**Consultation Response from: KC Environmental Health (Pollution & Noise Control)**

**2024/93041 - The Old Tannery, 224, Spen Lane, Gomersal, BD19 4PJ**

**Discharge of details reserved by condition 11 (validation report) on previous permission 2021/92255 for erection of 5 dwellings with associated access and demolition of existing extensions to commercial building**

**Condition 11 – Validation Report**

Appendix 3

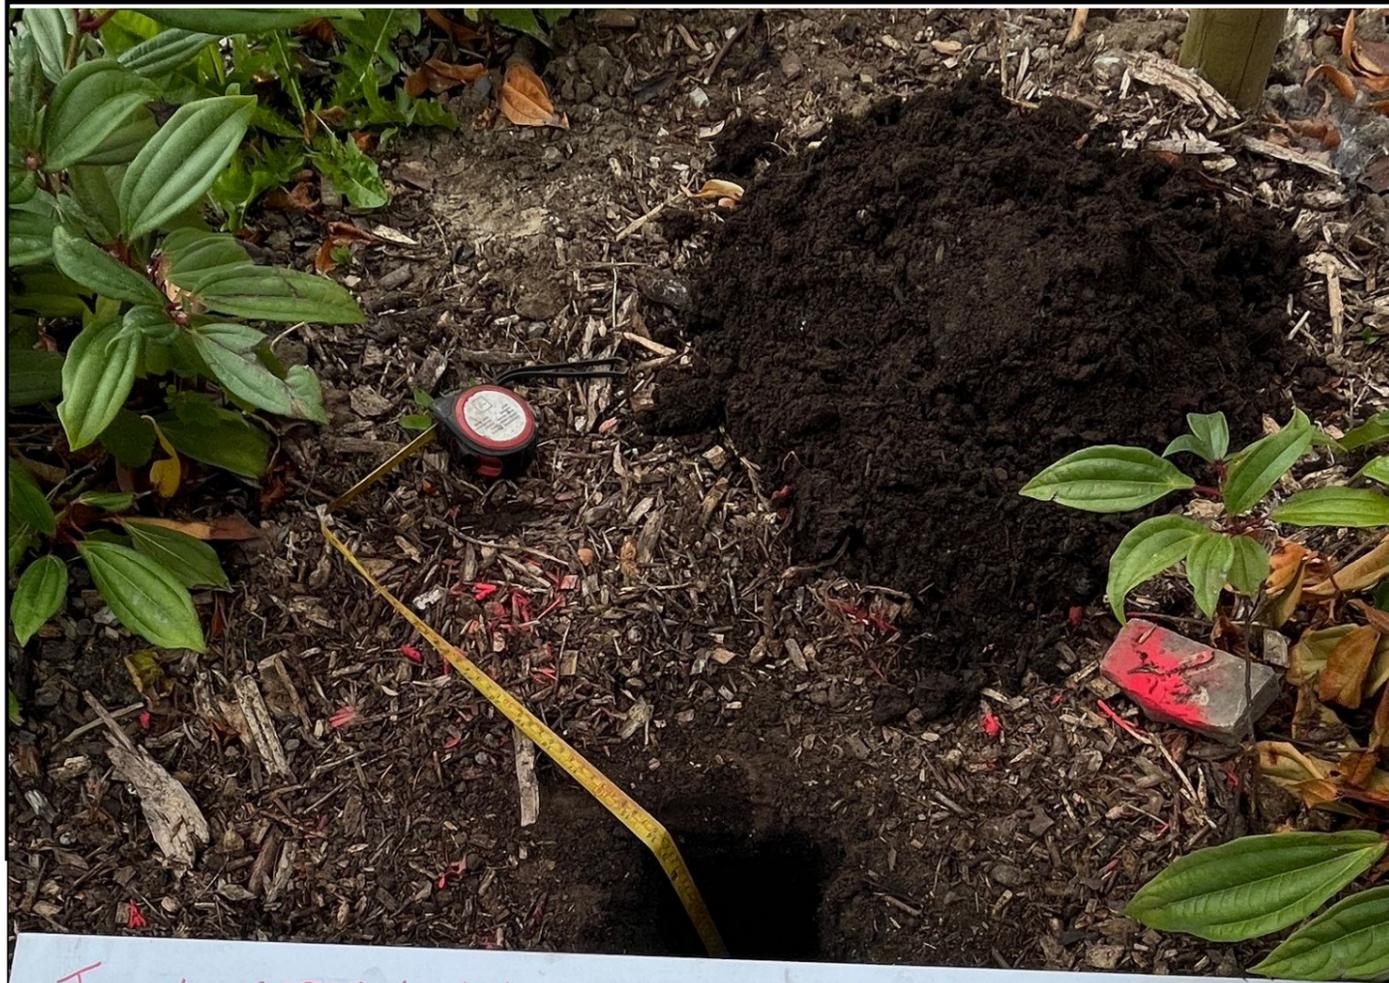
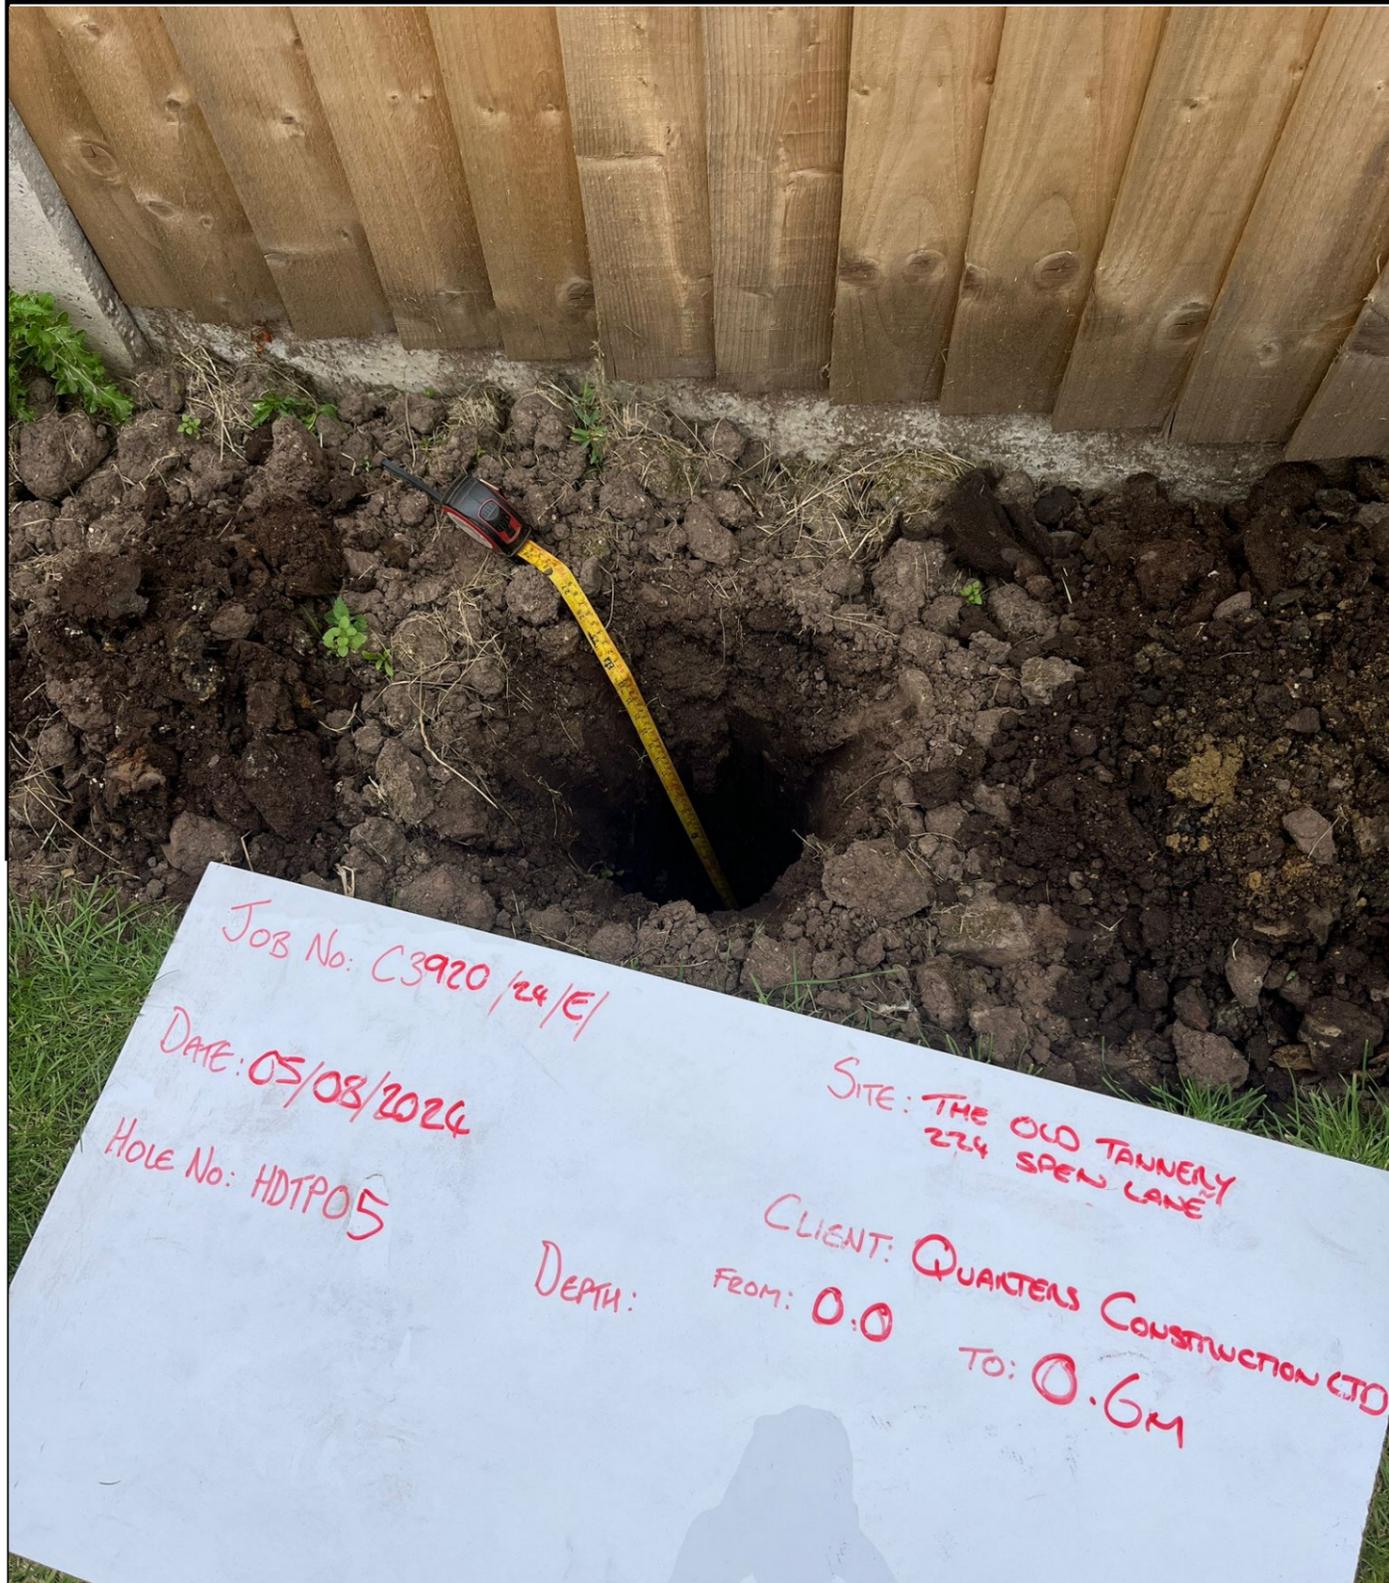
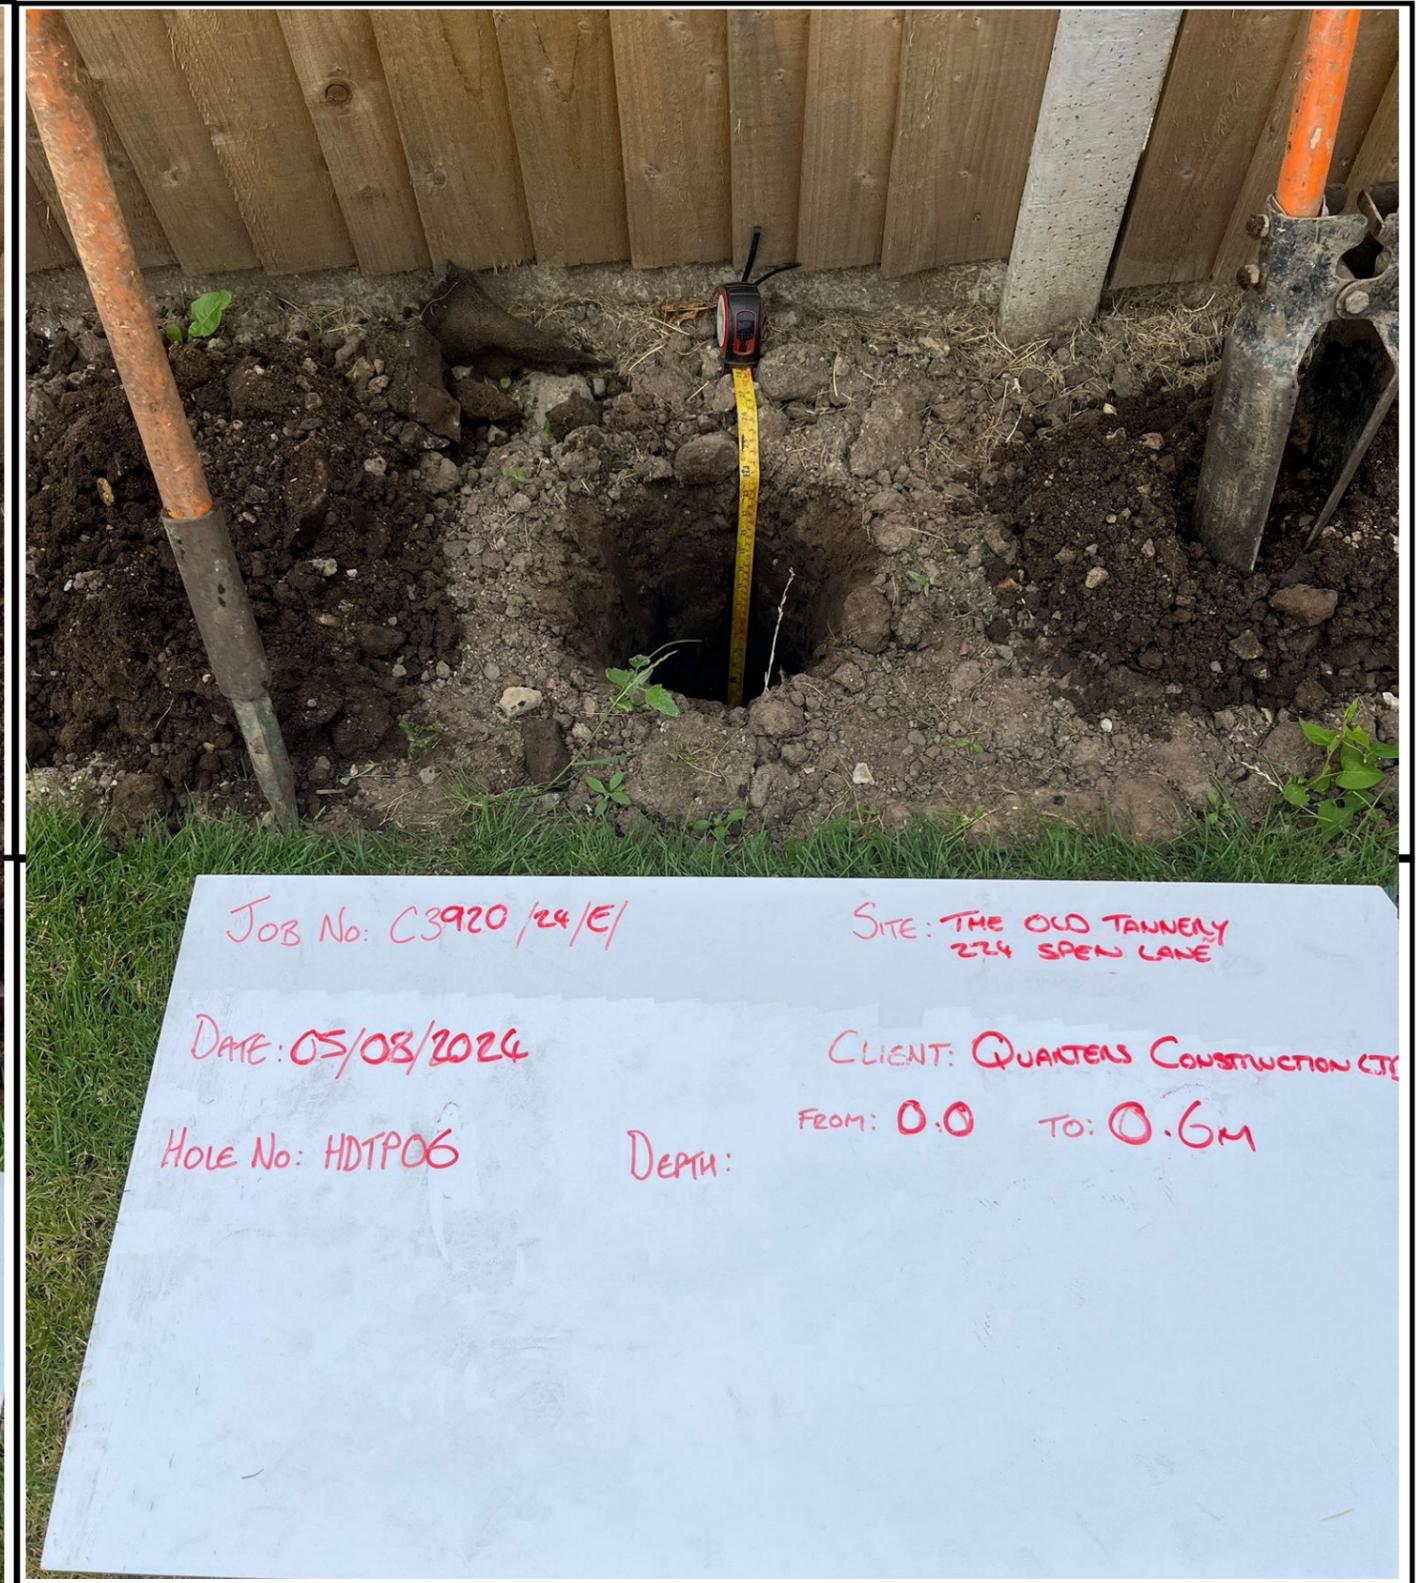
- The agreed clean cover system included a geotextile membrane. However, no membrane is reported in the trial pit logs or evidenced in the photographs. Further clarification on this point is necessary.
